# CITY OF ALBUQUERQUE

December 13, 2011

**Re: Spectrum Assisted Living, Grading and Drainage Plan**  
**Engineer's Stamp dated 11-21-11 (A12/D025)**

Based upon the information provided in your submittal received 11-22-11, the above referenced plan cannot be approved for Building Permit until the following comments are addressed:

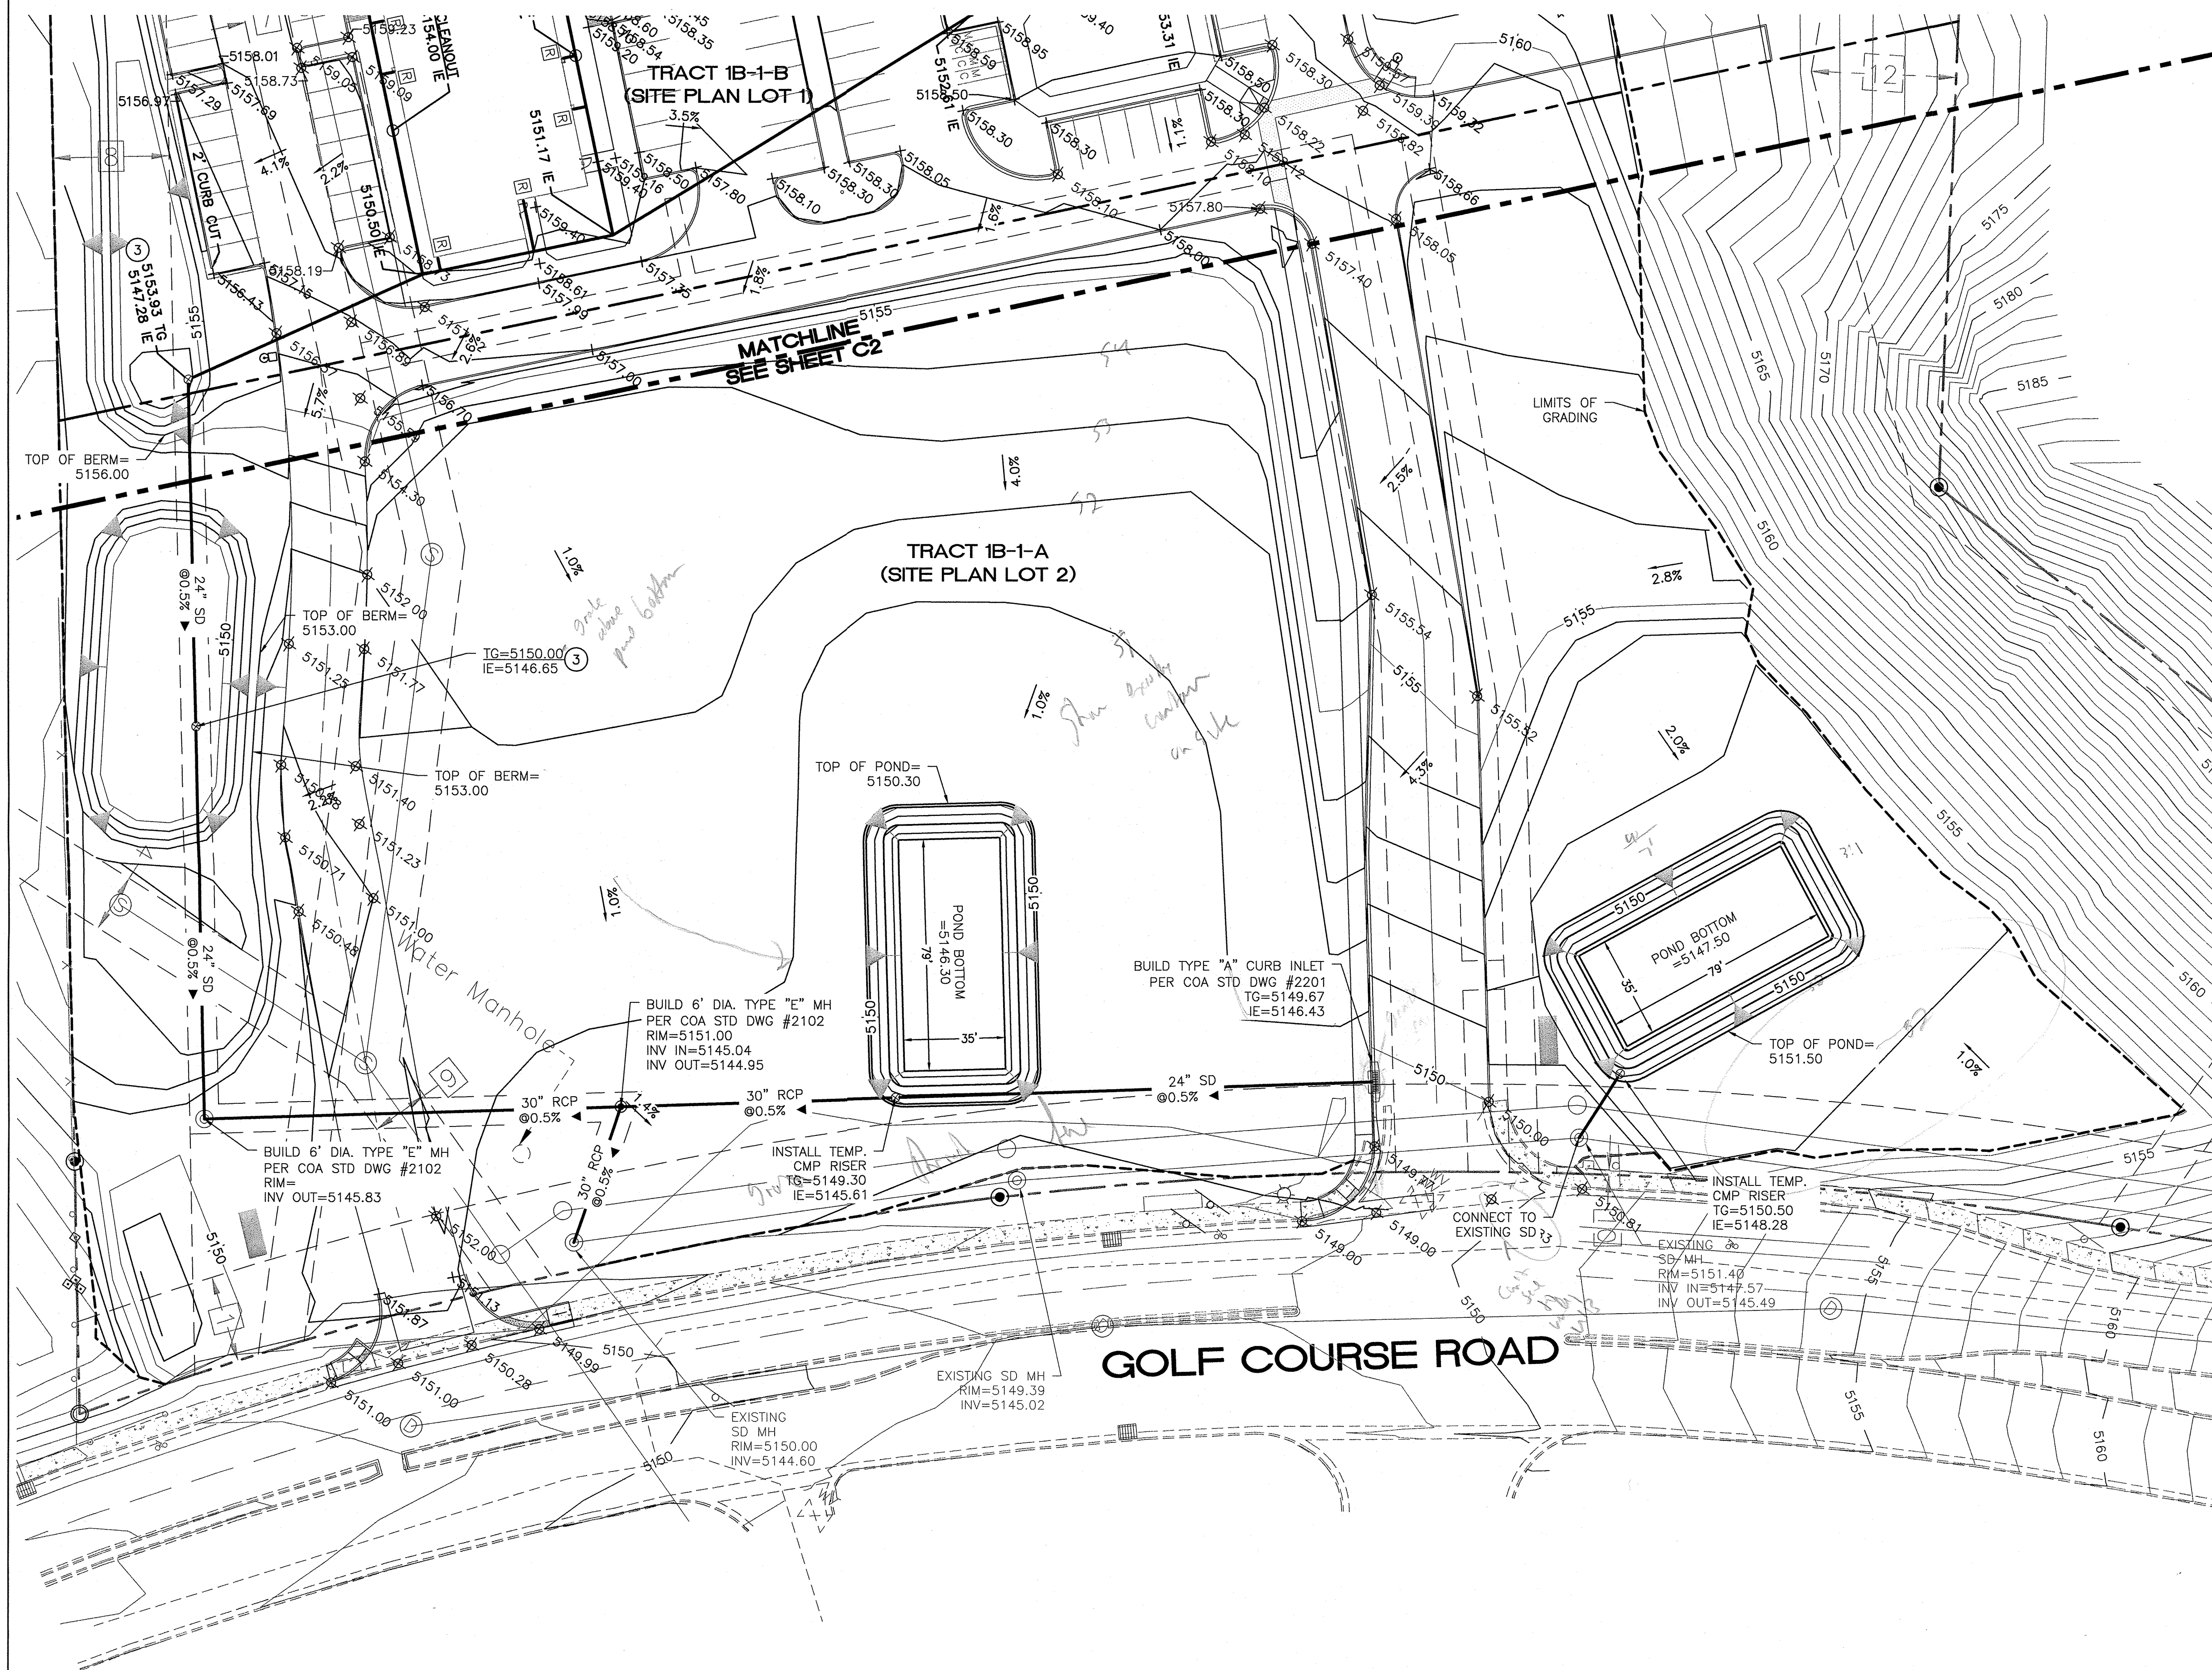
- Provide existing spot elevations around the perimeter at regular intervals as well as inside to support existing contour data.
- Provide existing contour data (legend?).

- Provide numerous (similar to the top of sheet C3B) proposed spot elevations in the parking/drive areas as well as near the buildings.
- Provide grades in west courtyard area of large building.

- Provide direction of roof flows, except the building with roof drains.
- It is not evident that the area behind/along buildings will drain.
- Show high points/basin divides with spot elevations.

- To accomplish stormwater quality and to prevent inlets from being buried, the inlets in the water harvesting ponds along the arroyo should be elevated above pond bottom. How high should they be elevated to accomplish these goals?

- Do the areas west of Golf Course Rd. drain to the sedimentation ponds? It is very difficult to tell in Basin 4.
- Hydrology could not find the benchmark information.

- The flow line elevation at the north entrance is covered with text.
- The slope near building FF 51761.7 and FF=5163.5 appear to be steeper than 3:1.
- Steep slopes near the property line could affect neighboring properties. Provide proposed spot elevations at the top and toe. Will these areas be revegetated?
